Your Reference SSD-77260958
Michelle Niles
Department of Planning, Industry and Environment
Via Major Projects Planning Portal

23 May 2025

**Submission to SSDA
20-24 Railway Parade and No.2-4 Burleigh Street, Burwood
Mixed Use Development**

1 HOTEL FACILITIES LEVEL 1
1:200

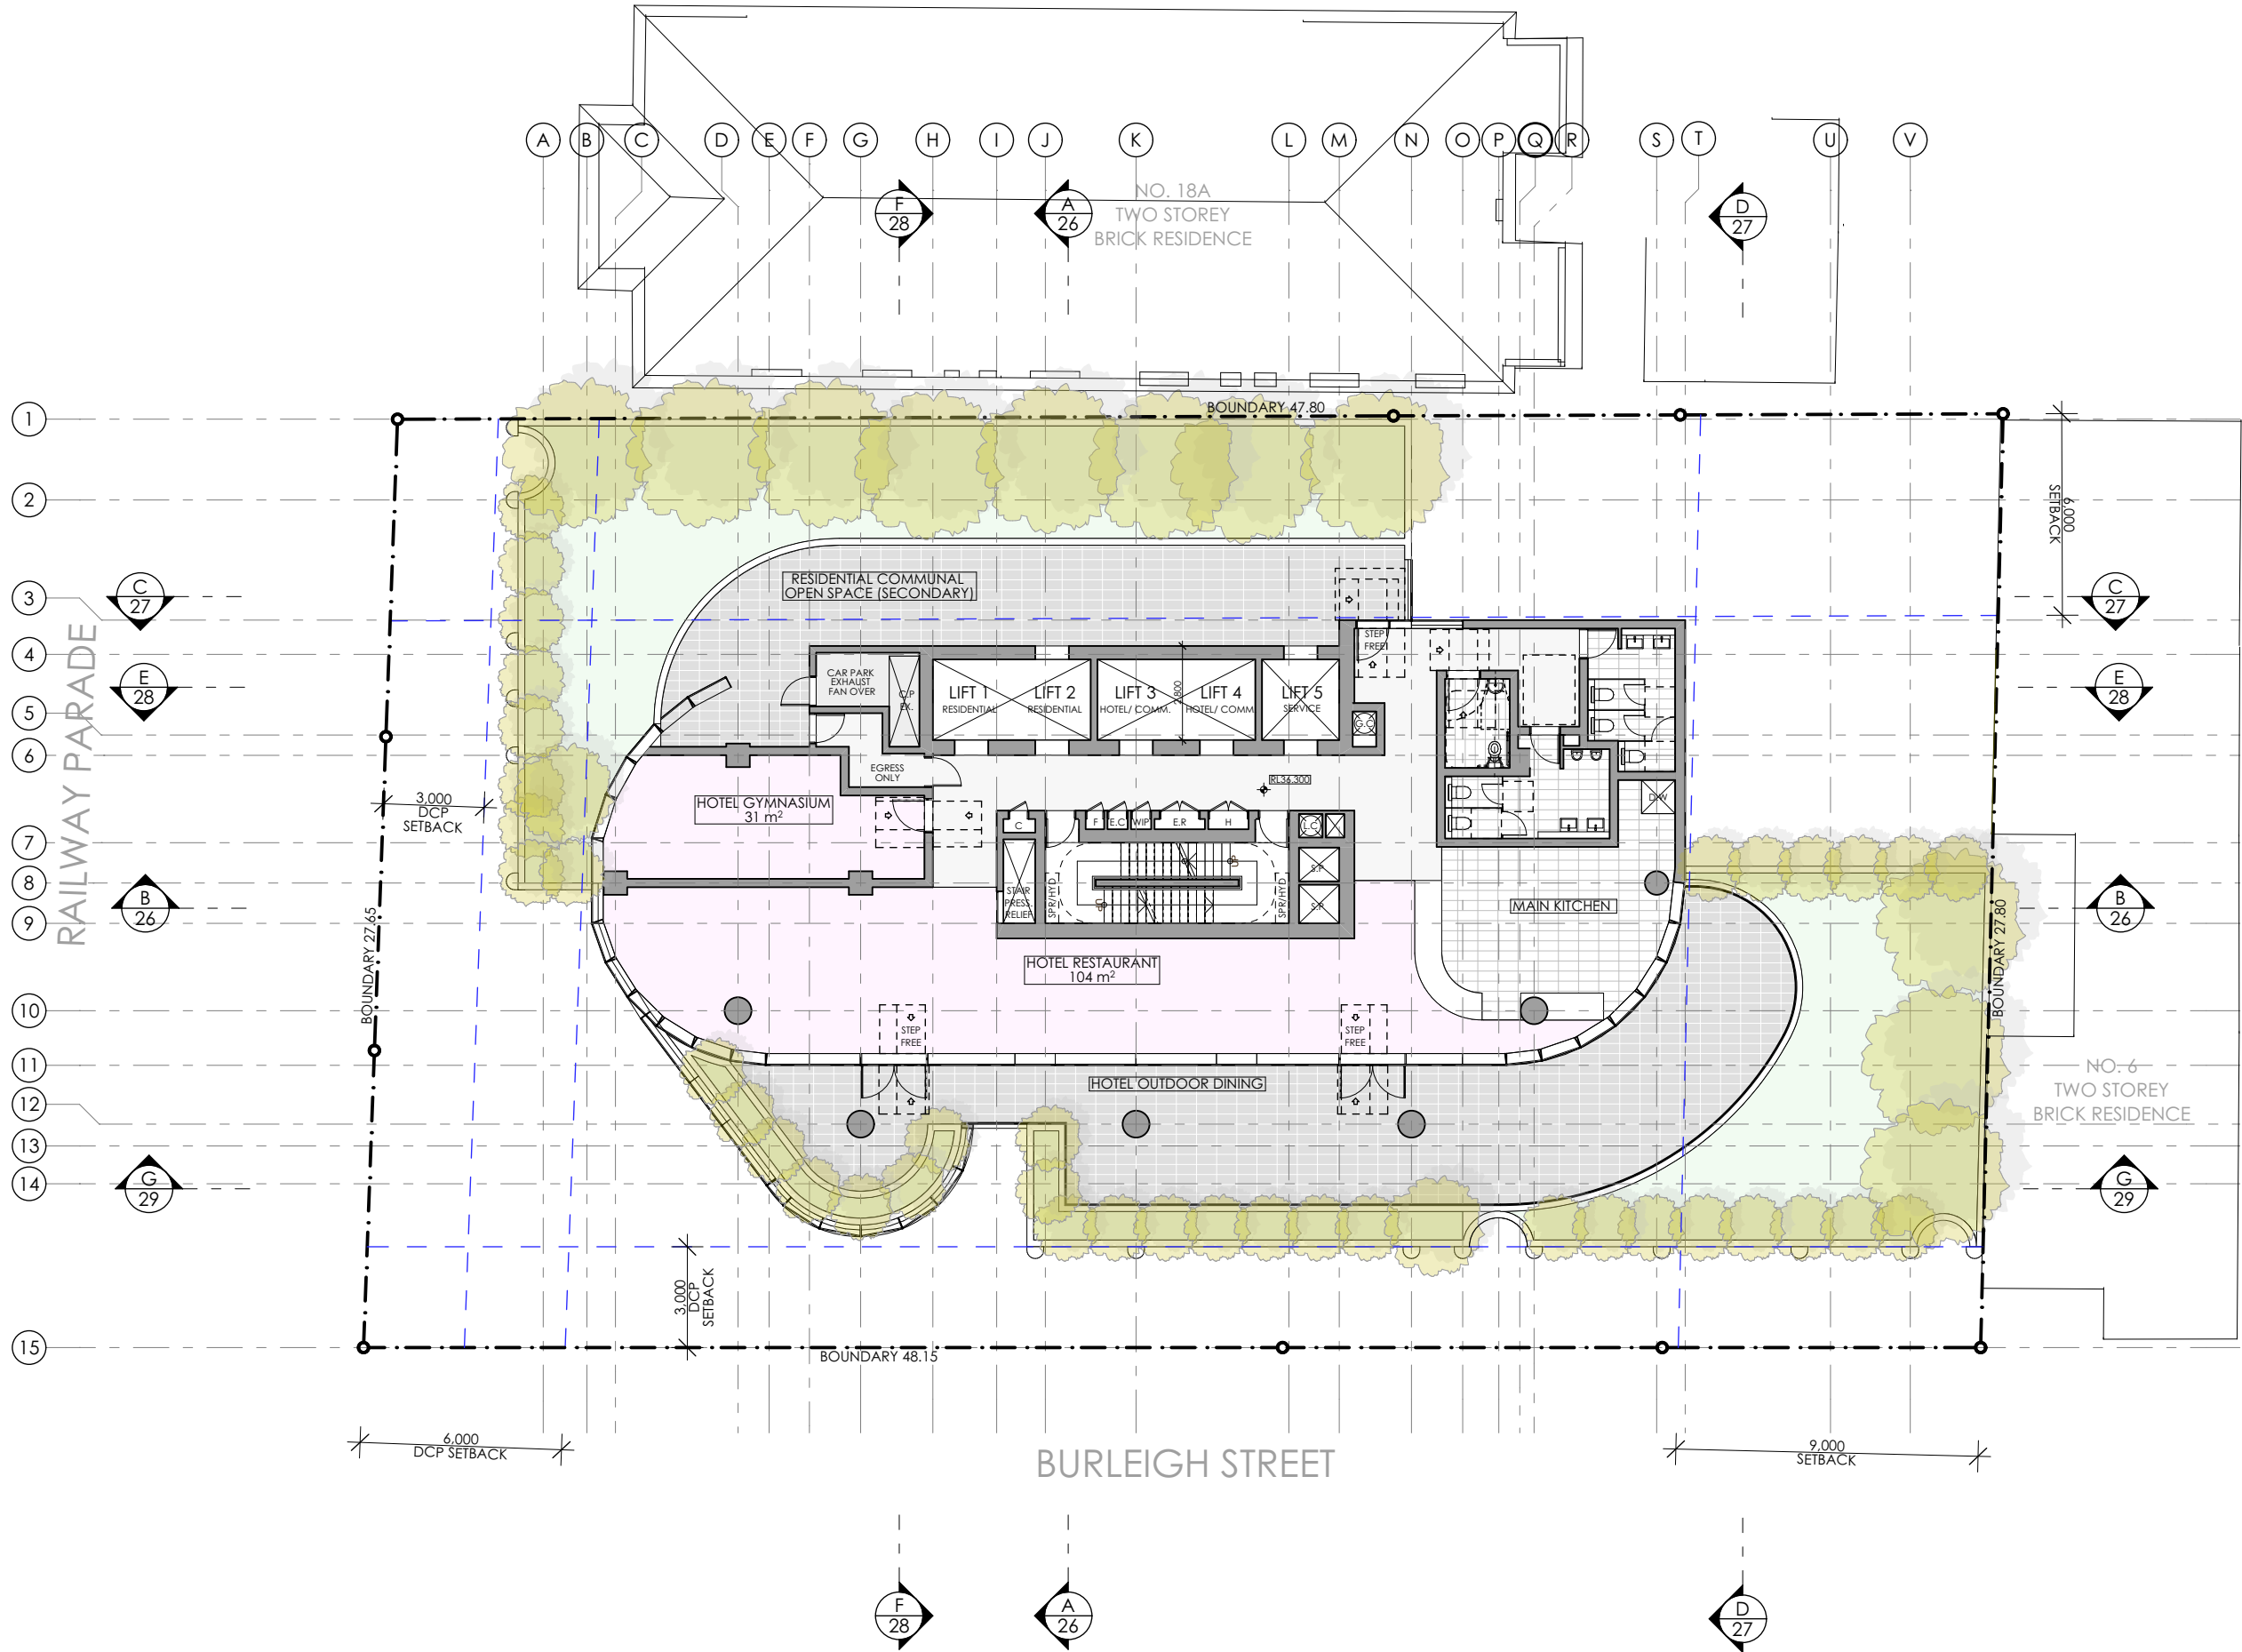
Level 1 has two function rooms that are Class 9b. There is also a pre function space at 71m² and an outdoor space.

1 RESIDENTIAL C.O.S LEVEL 38
1:200

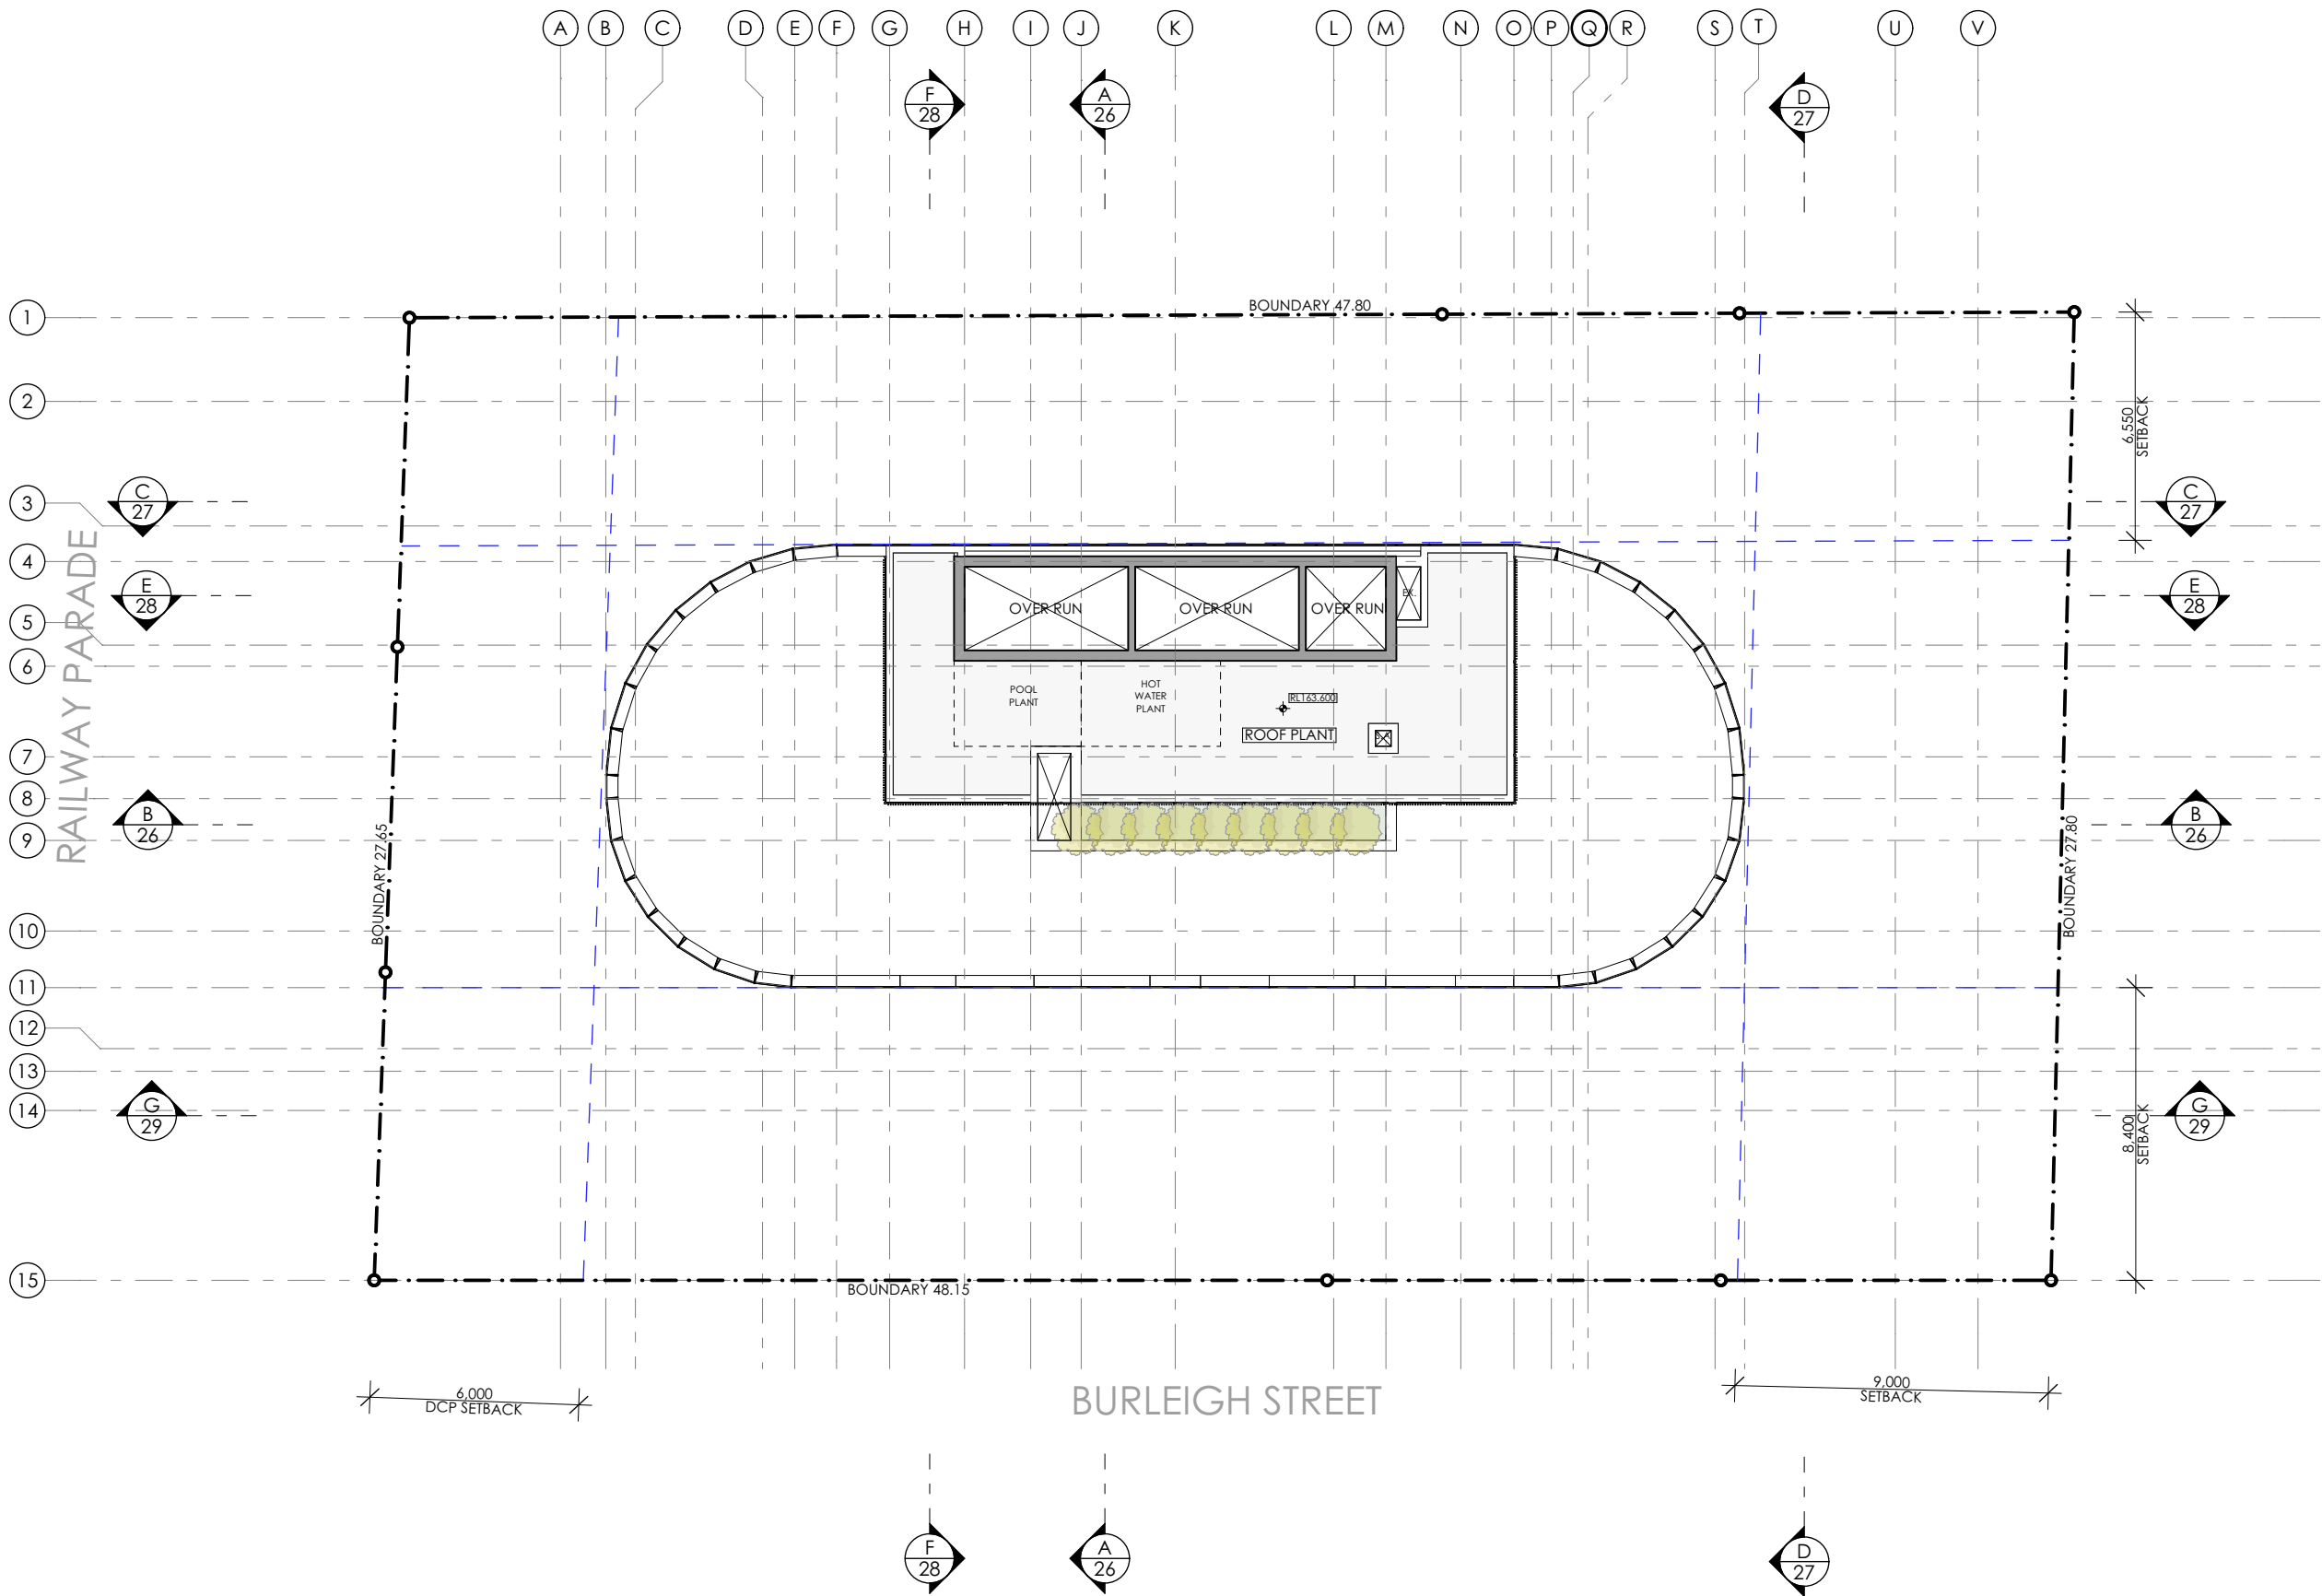
Level 38 is a Class 9b part of residential component of the building. It included a pool and open spaces for residents to share similar to private open spaces. Consideration to NCC 2022 Volume 1 Part G6 Occupiable outdoor areas is a requirement for the design team to provide details for the certifier.
